Addendum No. 1

RE: Contract ID C202745

Forsyth County (U-4909)

SR-2643 (Union Cross Road) From SR-2691 (Wallburg Road) To

NO.	BY	DATE	NO.	BY	DATE	SHEET NO.
1	SCC	12/5/2011	3			W-1
2			4			8

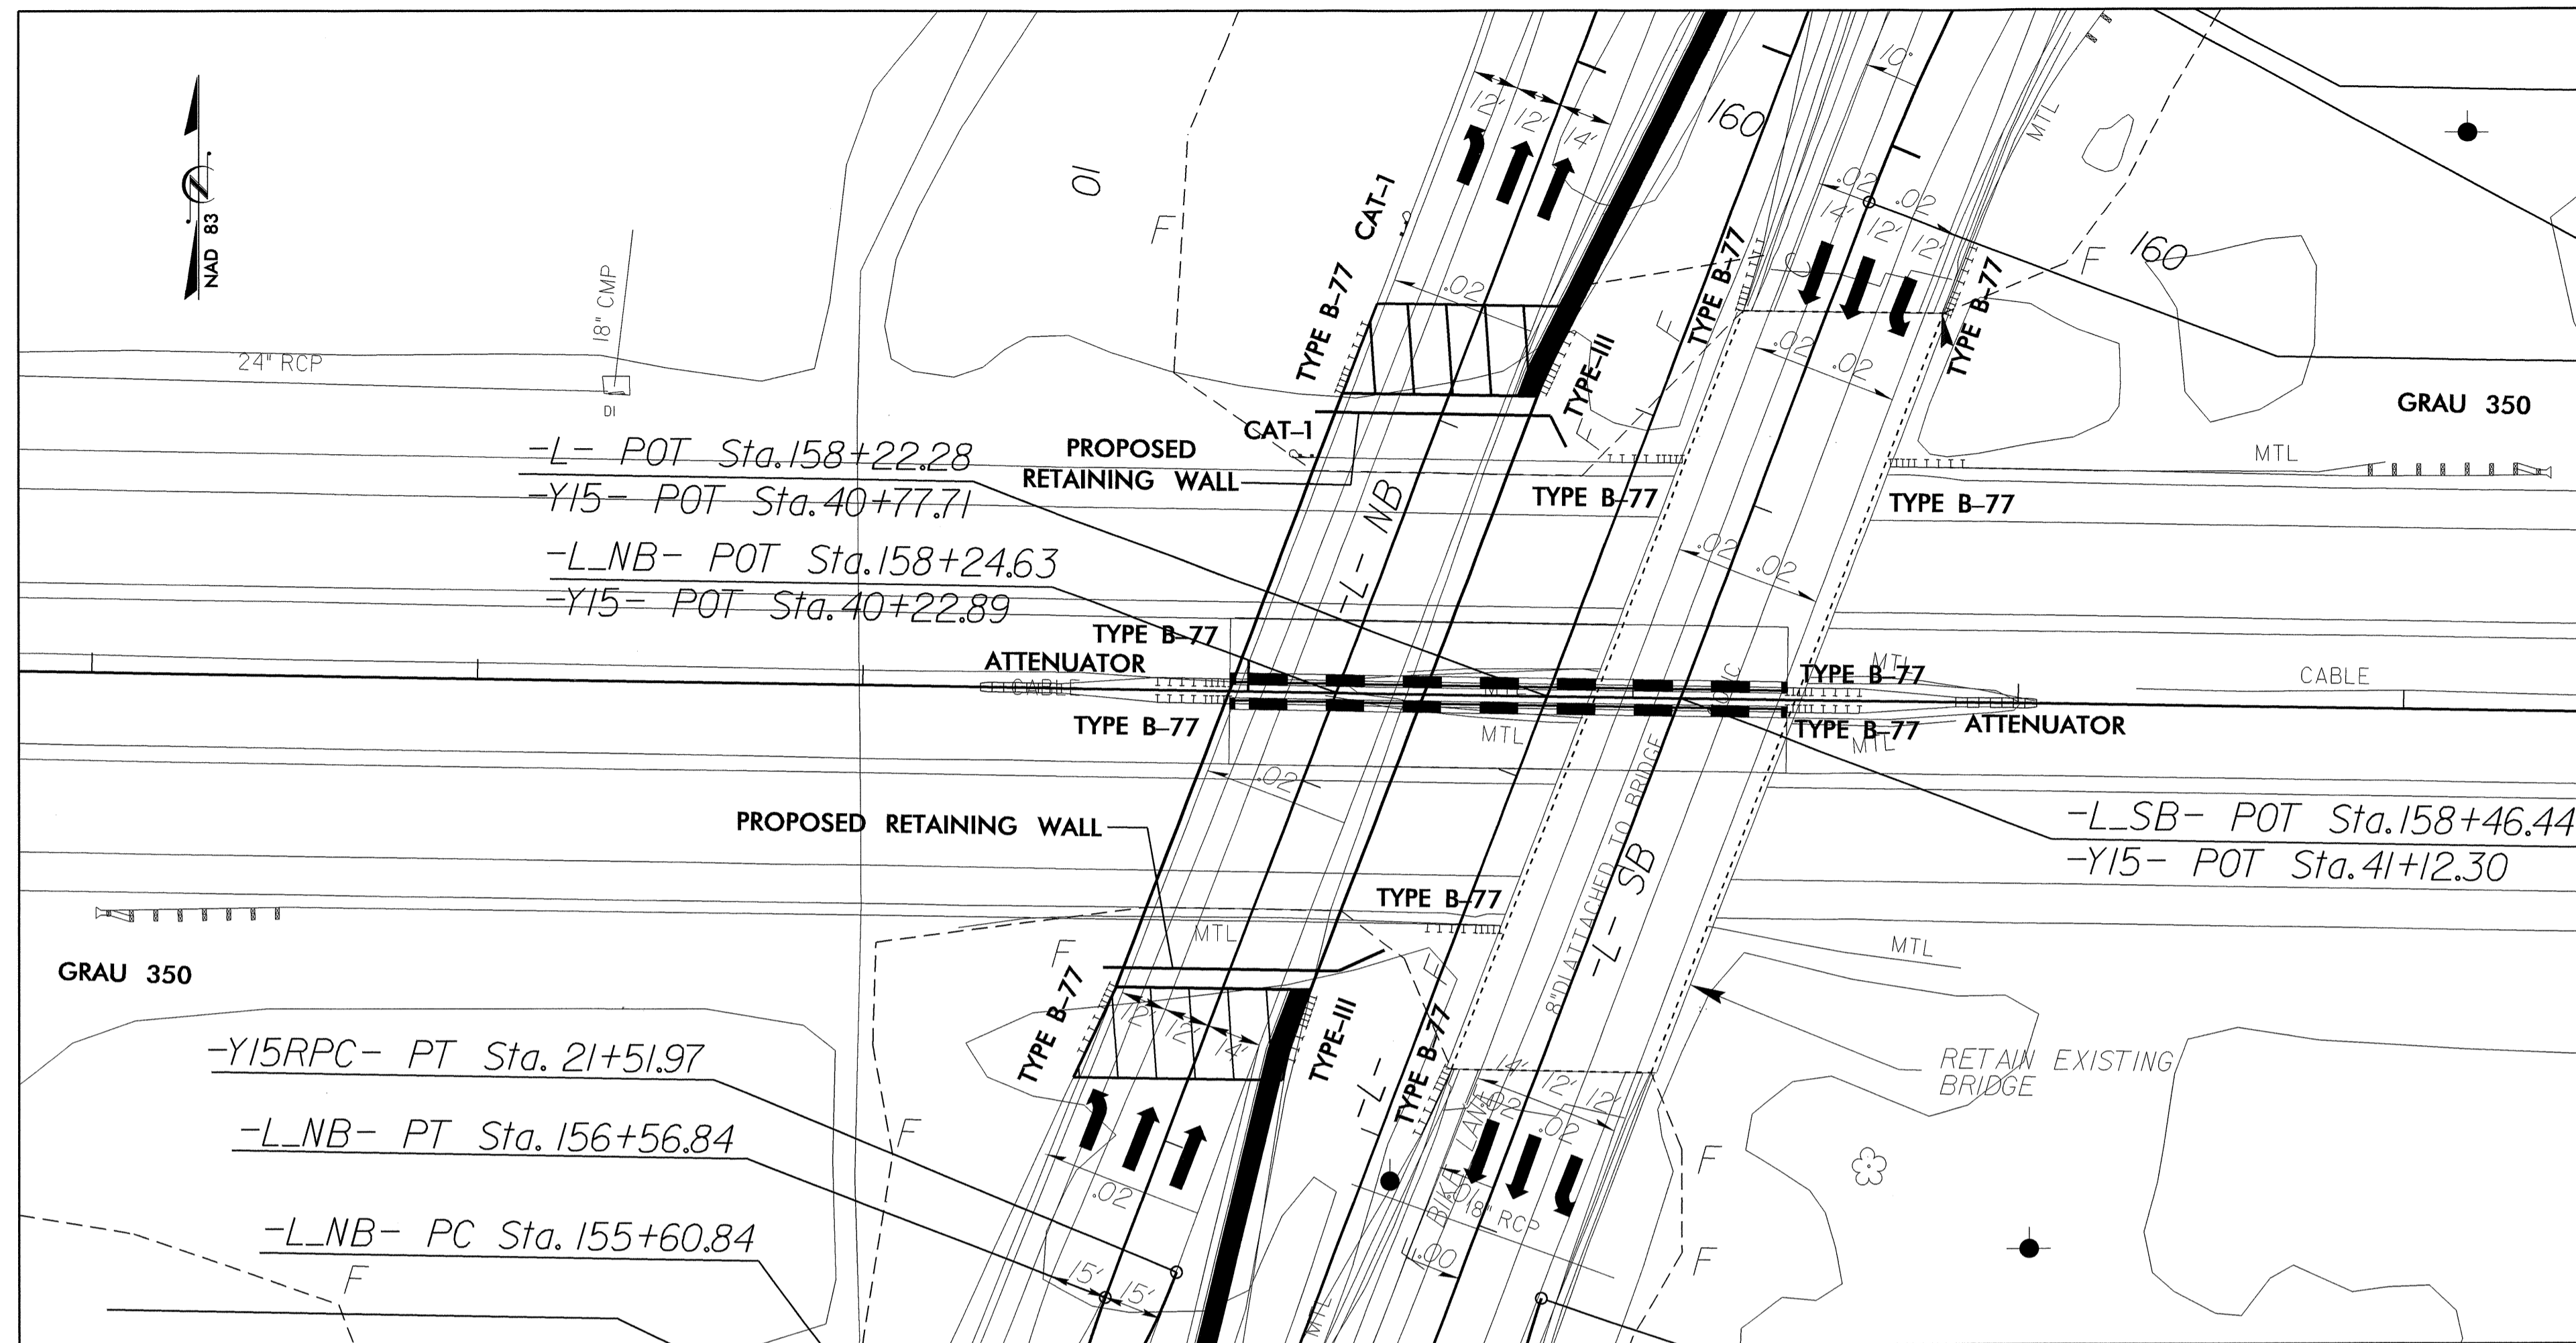
Sheet Nos. W-1 thru W-4 have been revised to make some changes to retaining wall details and the retaining wall quantity. Please void Sheet Nos. W-1 thru W-4 in your plans and staple the revised Sheet Nos. W-1 thru W-4 thereto. On Sheet No. W-7 the MSE Wall Typical Section has been revised. Please void Sheet No. W-7 in your plans and staple the revised Sheet No. W-7 thereto. On Sheet No. W-8 the notes have been revised. Please void Sheet No. W-8 in your plans and staple the revised Sheet No. W-8 thereto.
